Subject: Response to Submissions - Yiribana Logistics Estate (SSD-10272349)

Attachment 1: Environment and Heritage Group comments in relation to proposed stormwater management strategy for Yiribana Logistics Estate (SSD-10272349)

SSD-10272349 – Response to Submissions for Yiribana Logistic Estate

ESTATE BASIN 2 PLAN
SCALE 1:250

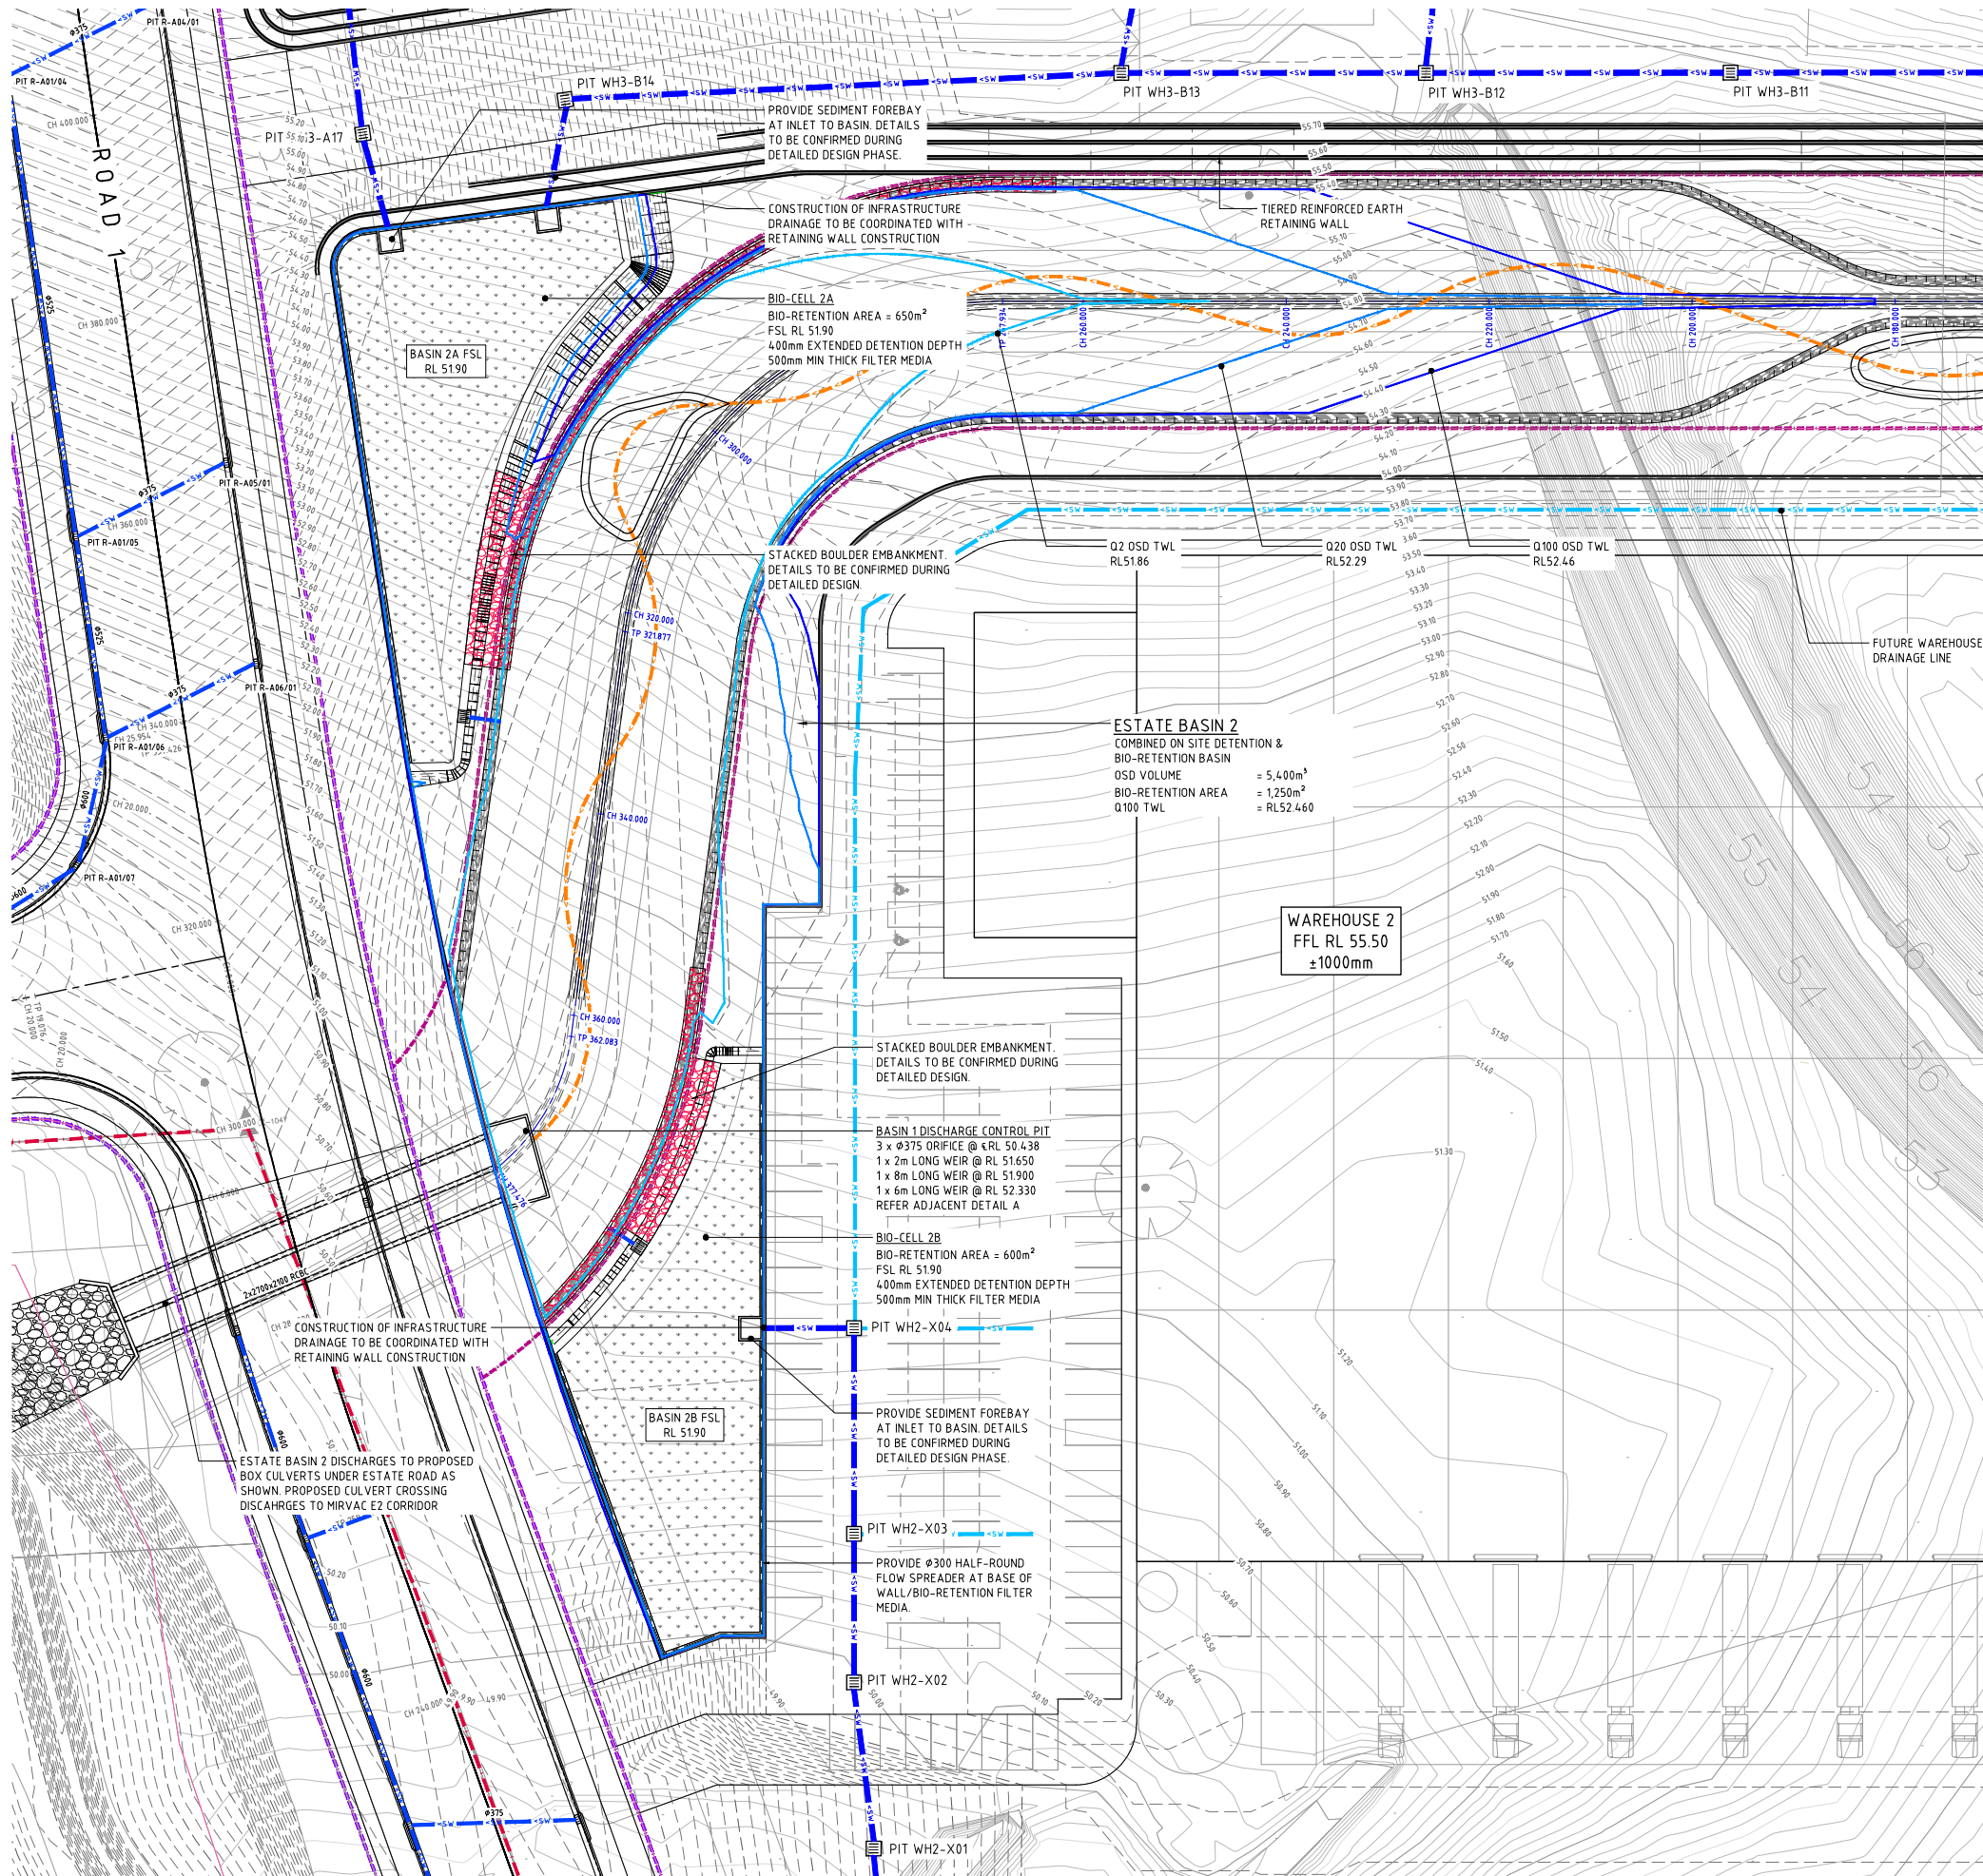
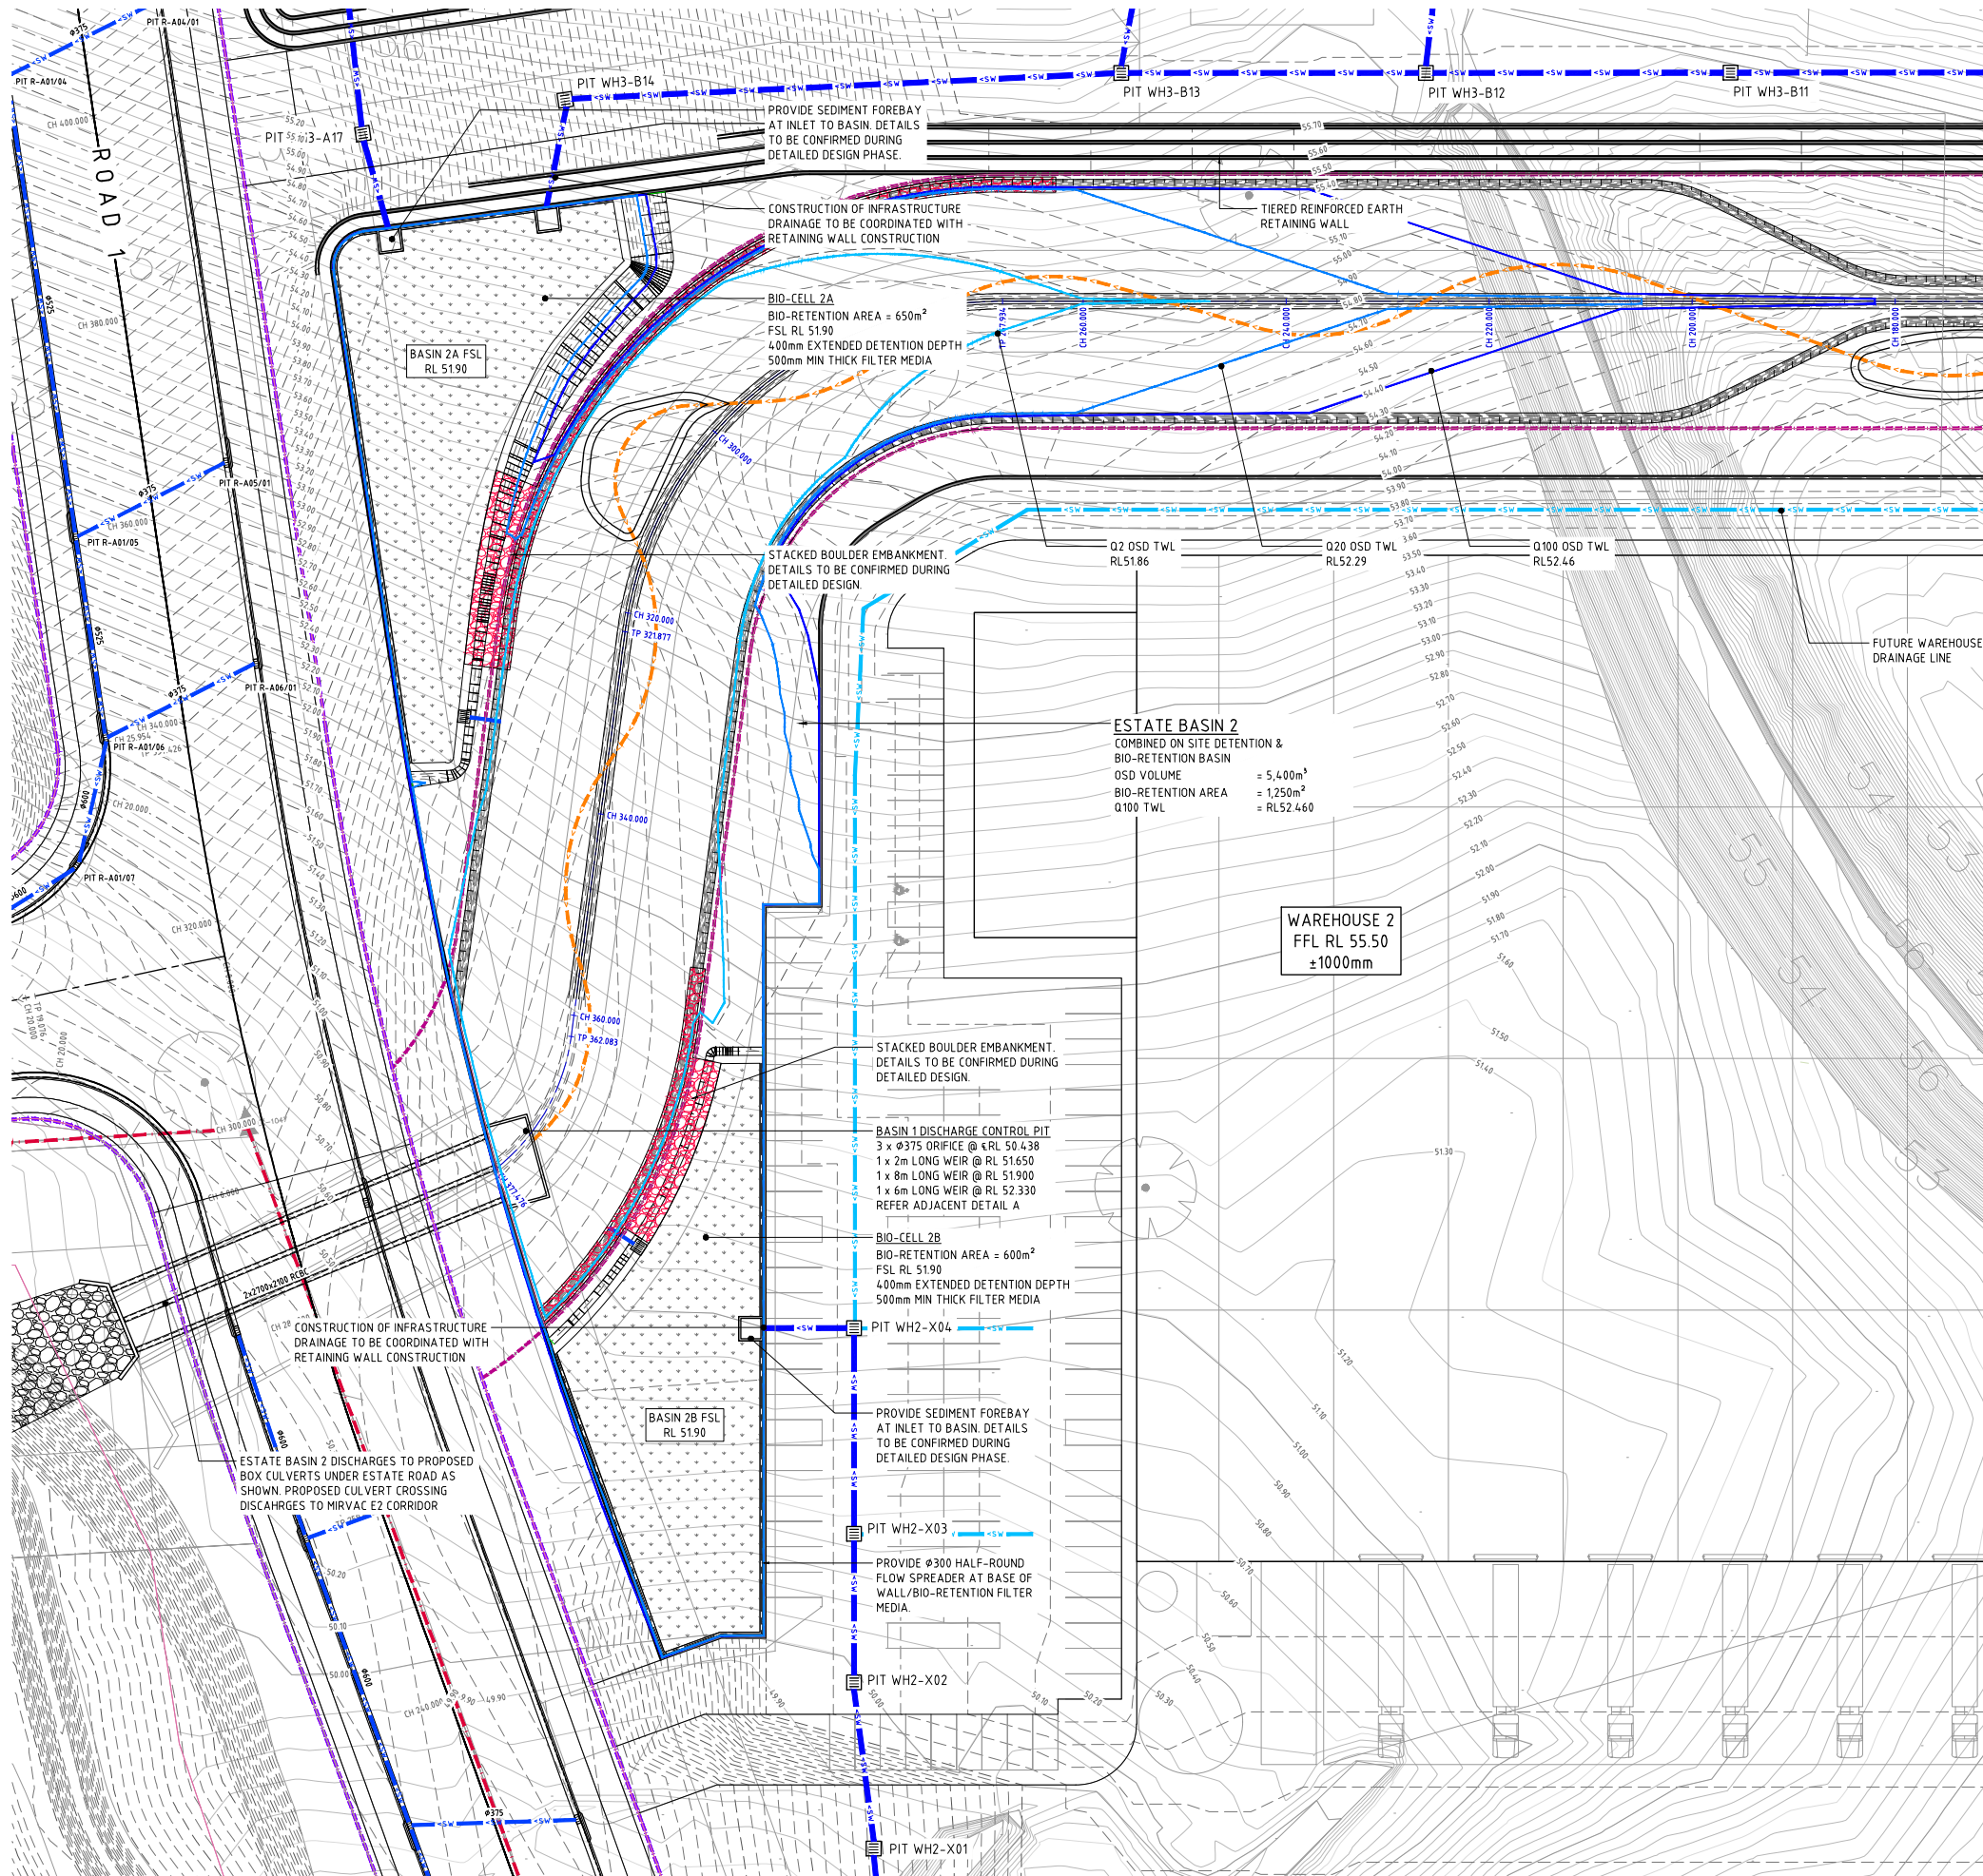
The design of OSD 2 is to be reviewed to ensure that it does not detract from the purpose of the corridor or prohibit the aims of the VMP.

Civil plan no. SSDA432 indicates that Estate Basin 2, which is a combined OSD and bio basin is located in the corridor. DPE is to ensure that the corridor is for 'riparian' purposes and not OSD and trunk drainage.

TIERED REINFORCED EARTH WALL DETAILS
SCALE 1:50

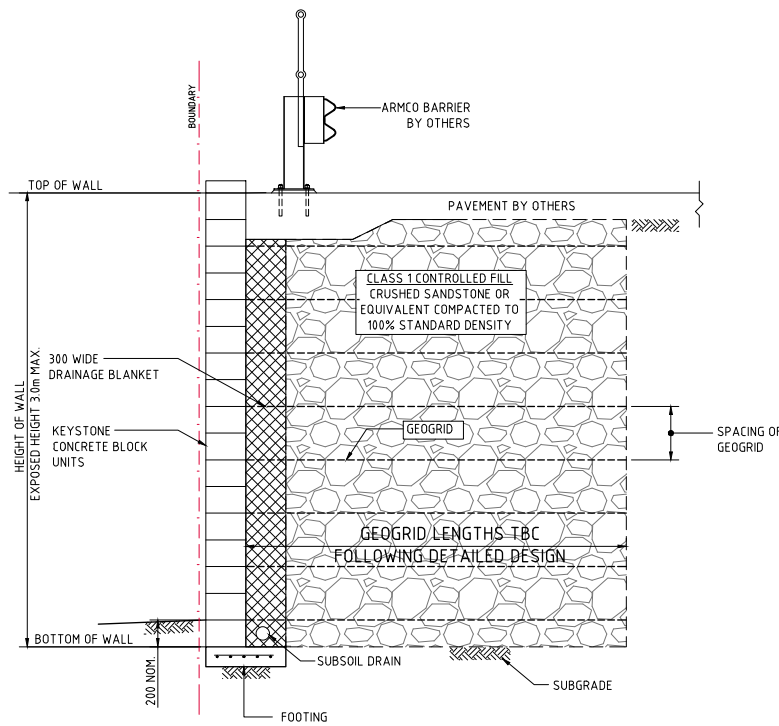
The landscaping of the tiered retaining walls is to be improved with ability for trees and shrubs to be planted at the base. This may require redesign, such as less tiers, with good quality planting (trees and shrubs) at the base. Landscape plans are to be elevated in design quality with better sectional detail provided.
